DEPARTMENT OF PUBLIC WORKS

MEMORANDUM

TO: Community Development Services
FROM: Taylor Gustafson, Environmental/Transportation Planner
DATE: September 28, 2018
SUBJECT: Public Works Review of Final Plat LP-18-00006

DATE : 2018-08-30 | JOB NO. 998-766-016-0002  
DRAWN BY: C.A.F./R.F.G. | SHEET 1 OF 5

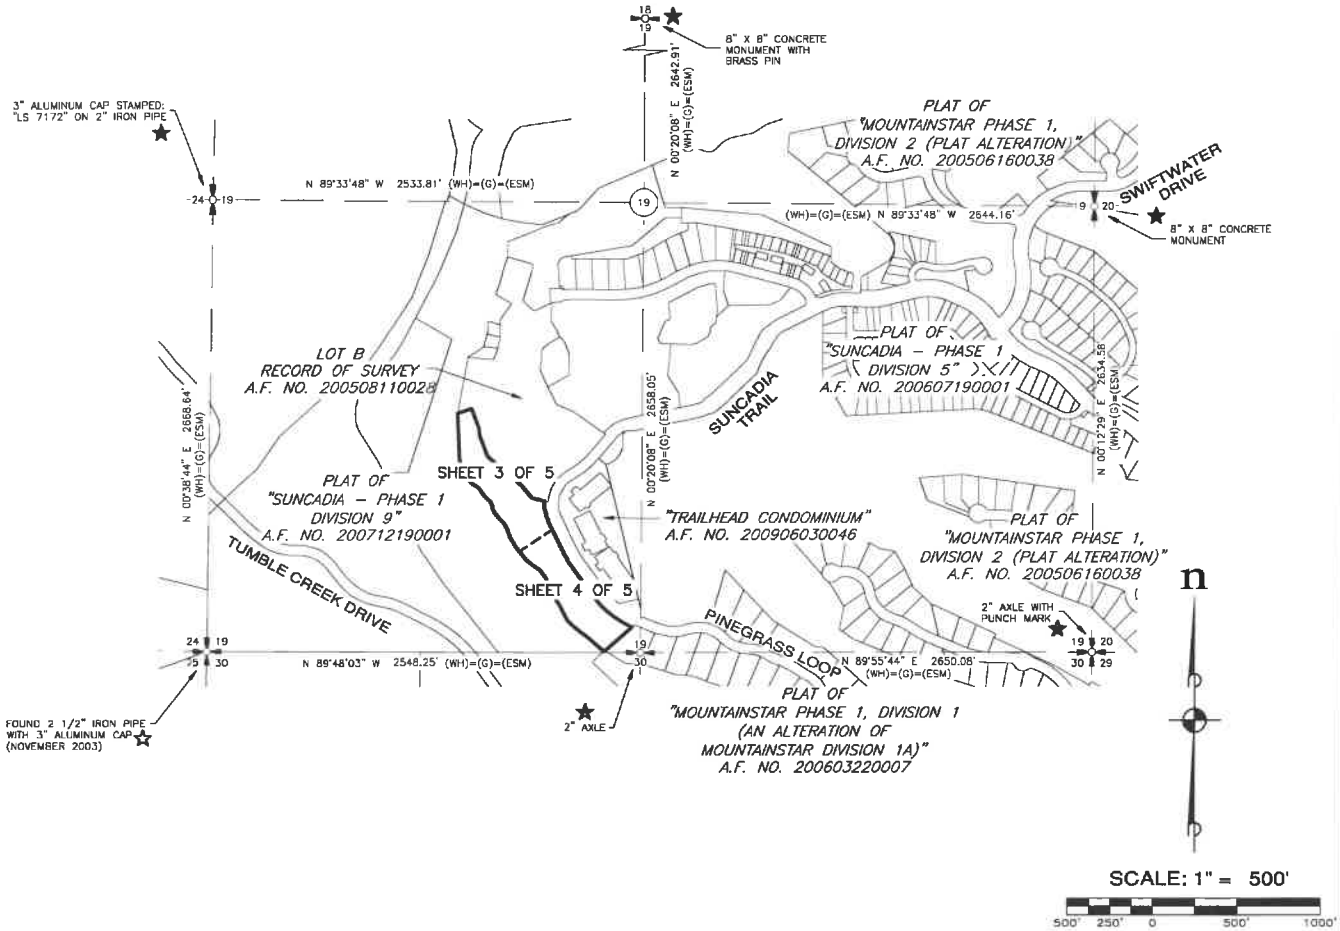
1. On sheet 1 the Recording Certificate is shown in two locations.
2. Sheets 3 and 4 are missing the surveyor stamp.
3. Suncadia Trail should include the ownership and surfacing.
EX: Suncadia Trail (Private R/W – Paved)
4. The additional R/W to be dedicated to Suncadia Trail should be labeled as "(additional right of way herein dedicated)"
5. Sheet 4 includes a legend item "Found corner as noted". Please note what was found in the two locations containing this symbol.
